**KIRKLEES METROPOLITAN COUNCIL
INVESTMENT & REGENERATION SERVICE**

**DELEGATED DECISION TO DETERMINE PLANNING APPLICATIONS TO
CARRY OUT DEVELOPMENT WITHOUT COMPLIANCE WITH PLANNING
CONDITIONS PREVIOUSLY ATTACHED**

Reference No: 2021/70/91072/E

Description: Variation of conditions 2. plans and 3. materials on previous permission no. 2019/93364 for erection of two storey extension with balcony, detached garage, porch and external alterations

Project	Proposed Extensions and renovations at 6 Barnsley Road Flockton	01924 380873	F	Scale	1:100
Drawing	Plans and elevations	Date 06/03/2021	R	D	1:200
		Drng No	2

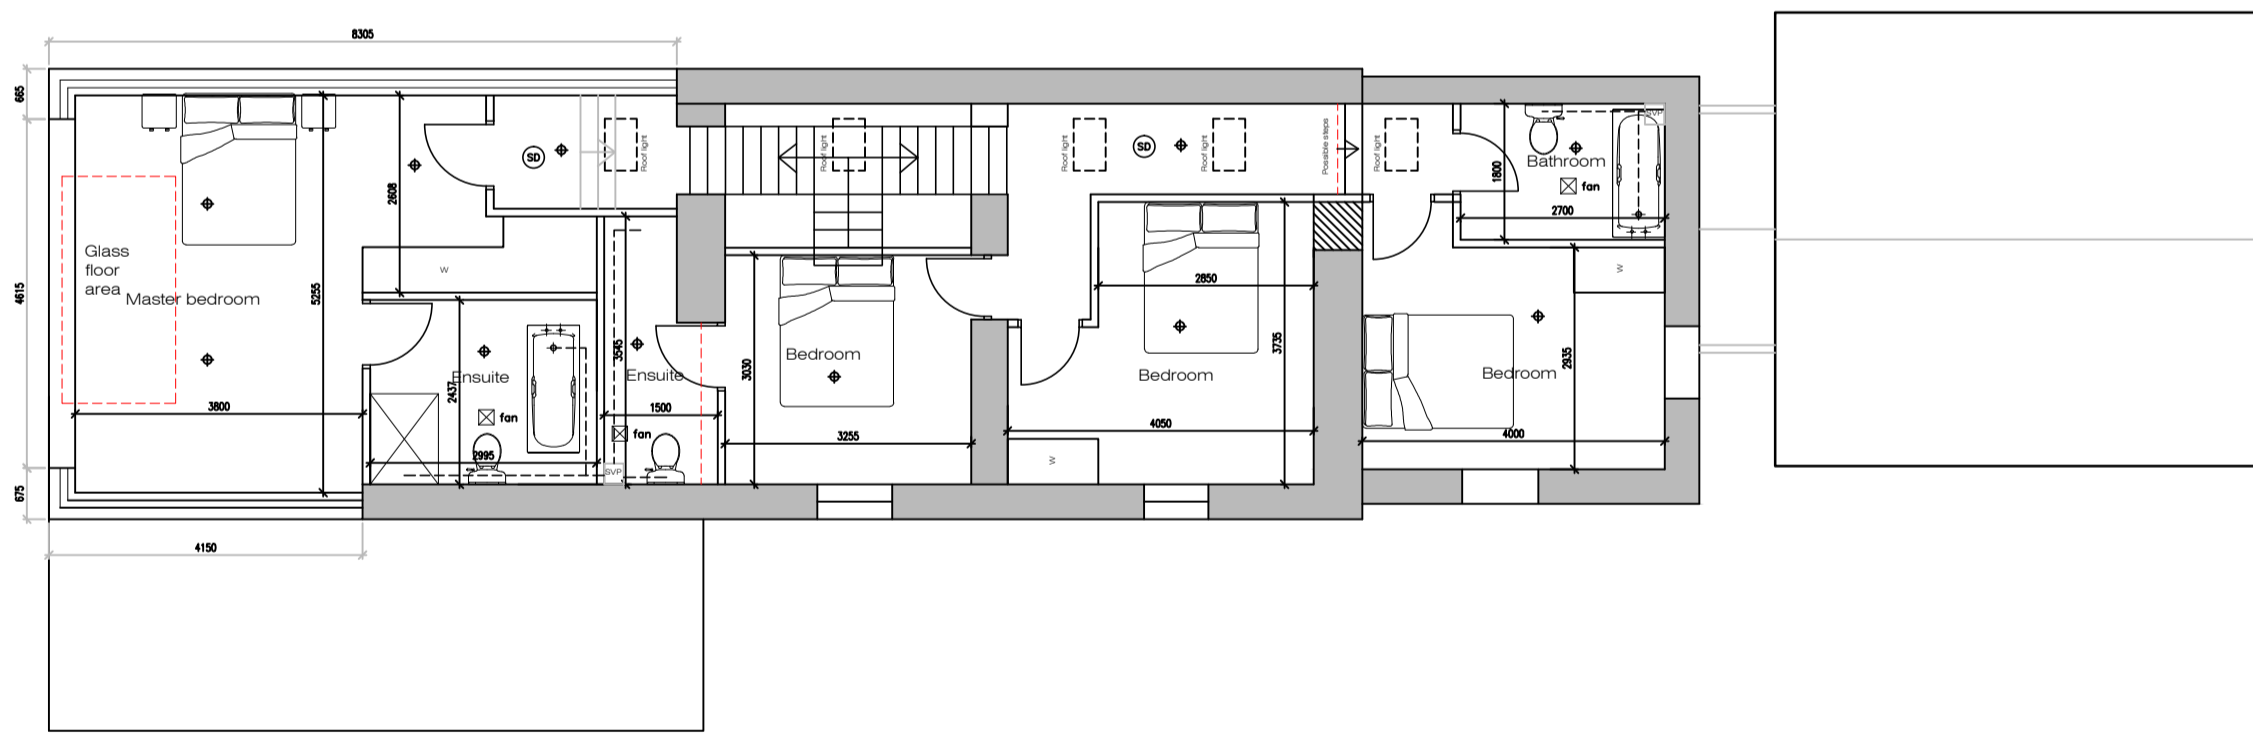
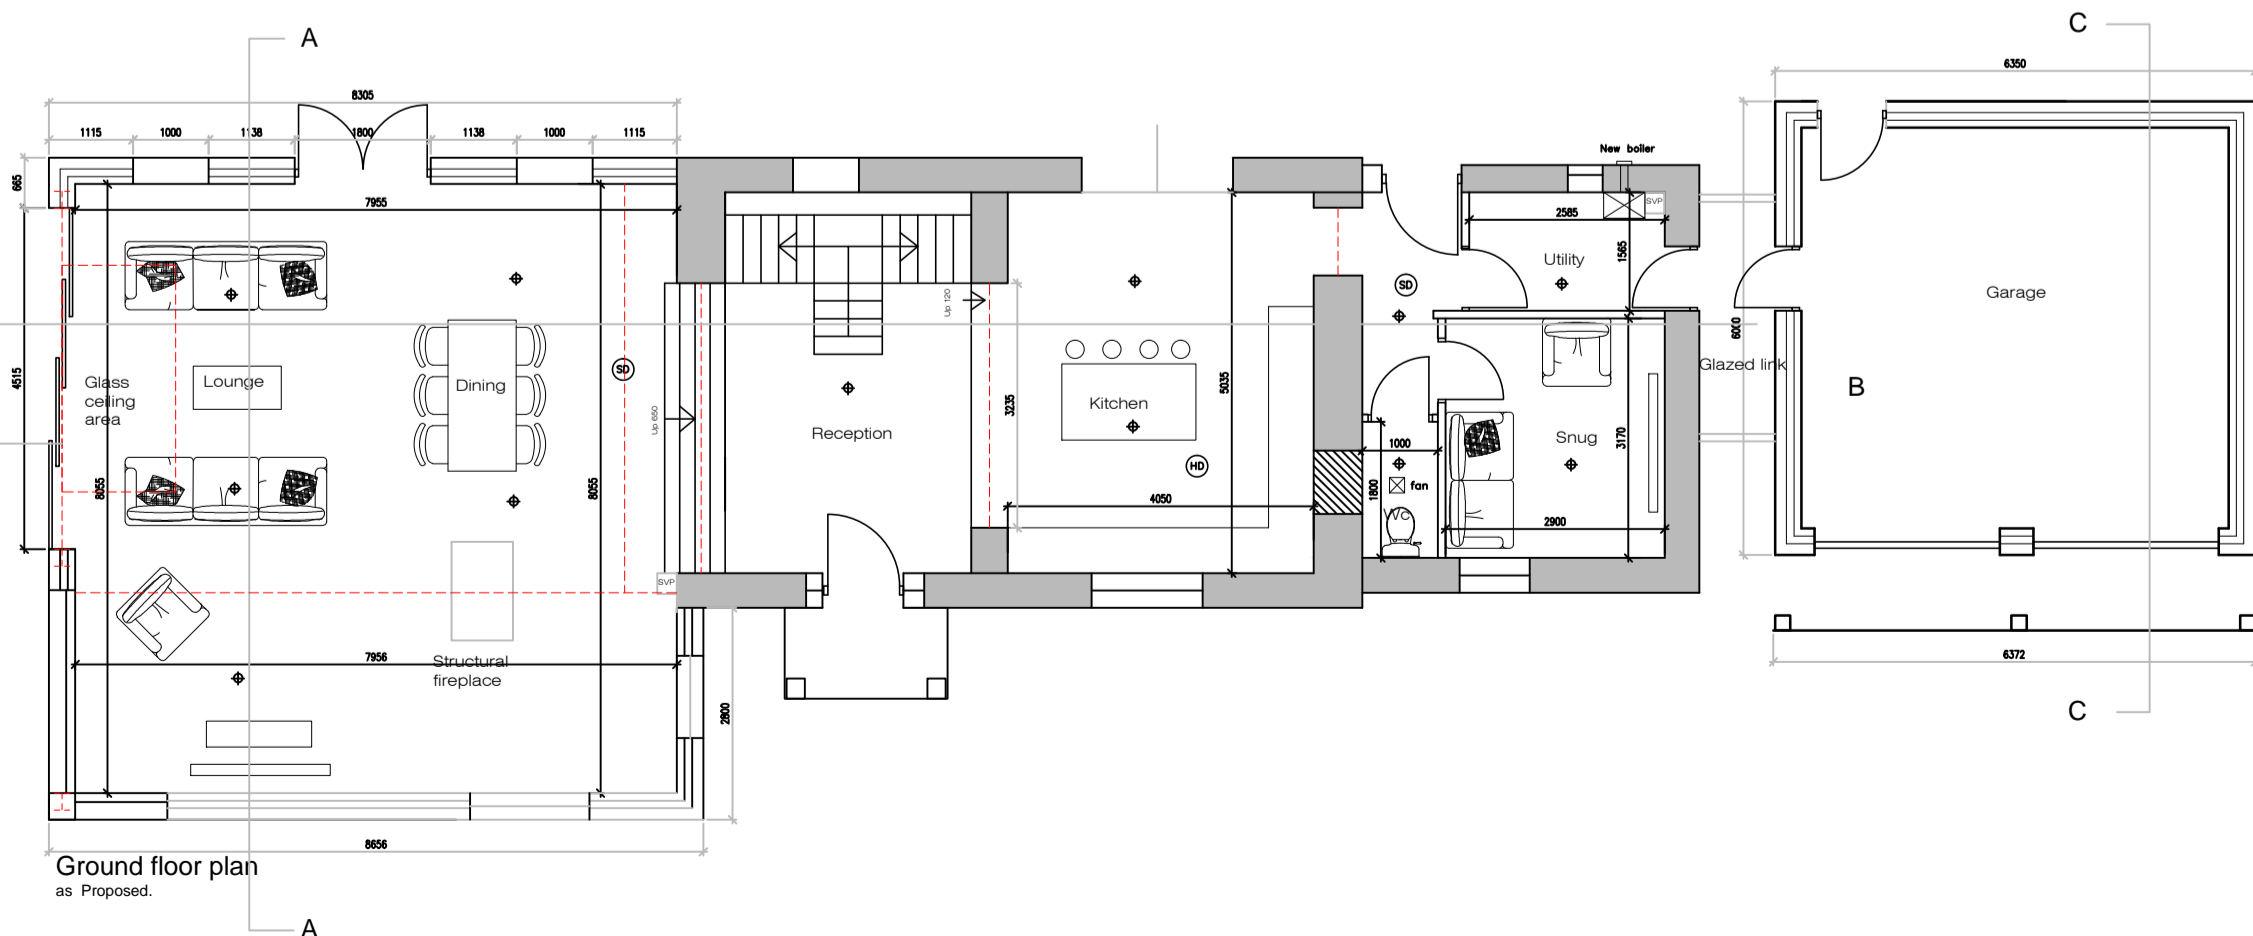
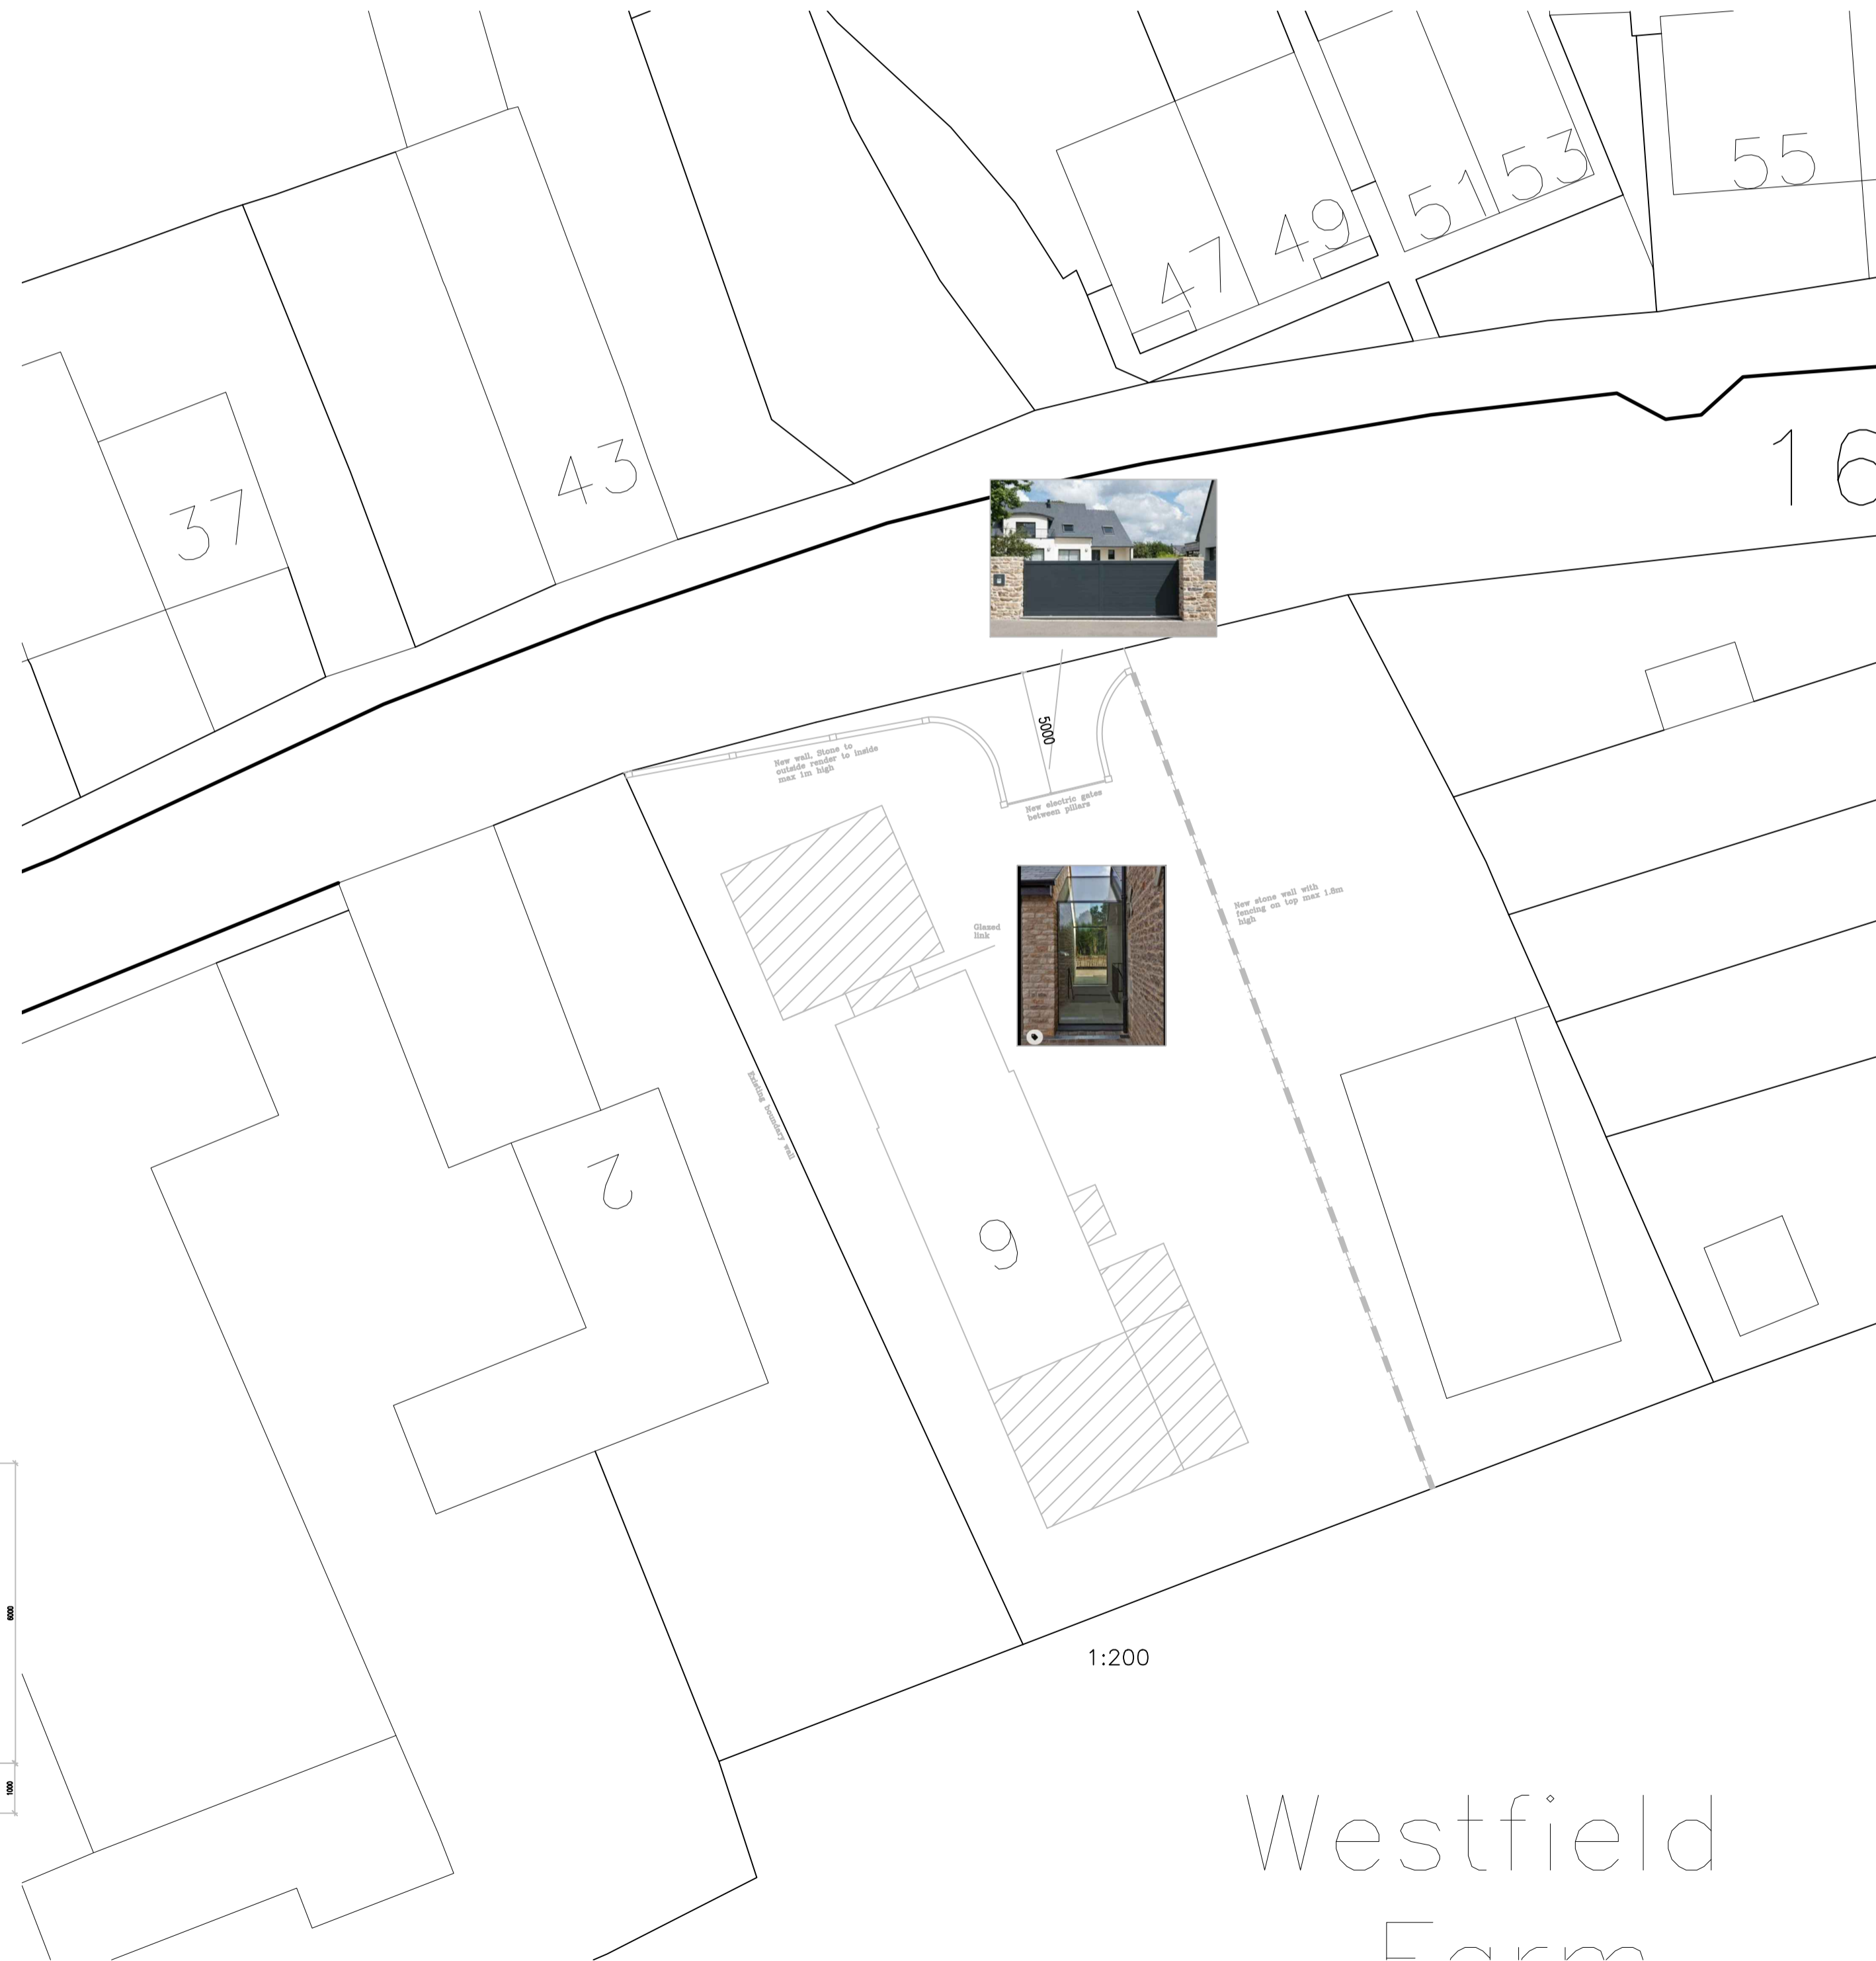
The majority of the works have already been assessed and agreed. This assessment will only consider the proposed changes which are the attachment of the garage, the repositioning of the porch and the use of aluminium for the two-storey glazed feature.

The double garage is still proposed to be a large structure, albeit now to be attached to the dwelling with a glazed link and it would be visible from Barnsley Road. Nonetheless, given the garage is still to be situated at a lower land level than the road, it is considered that the visual impact on the street scene is likely to be fairly limited. The garage would be approximately 6.3m by 6m; the scale of which would be not significantly greater than necessary for accommodating two vehicles, the use of materials would be to match the main house and the detailing will form an acceptable appearance relative to the host property. It is considered therefore that the attached garage is, on balance, acceptable from a visual amenity perspective.

The scale of the rear extension has been agreed for the most part. The additional depth to the single storey element would not substantially increase the extensions. The current proposal would remove the balcony and alter the glazed feature from oak beams to black aluminium. The framing would not be as thick and would afford a more contemporary appearance. However, this is considered to form an acceptable relationship with the house and its surroundings.

The porch would be repositioned. However, the scale is the same as approved and would still form an appropriate feature.

The use of small, pitched roof dormers over the first-floor windows in the west side elevation would make modest additions to the property, in keeping with the style of the property.

The plans now also show a 1m boundary wall at the front which is angled from the road with a recessed electric gate to a height of 1.8m. this are does have a mix of stone and timber boundary treatments, albeit at a low level of 1m or less adjacent to the road. As such, this would not be out of character with the area.

Negotiations took place around the boundary wall and electric gates. Although the initially requested height of 1.8m with a 4.5m recess for the vehicle access with an electric gate, was considered unacceptable, this was amended to a 1m-high wall and a 5m recess, which Highways DM considered acceptable.
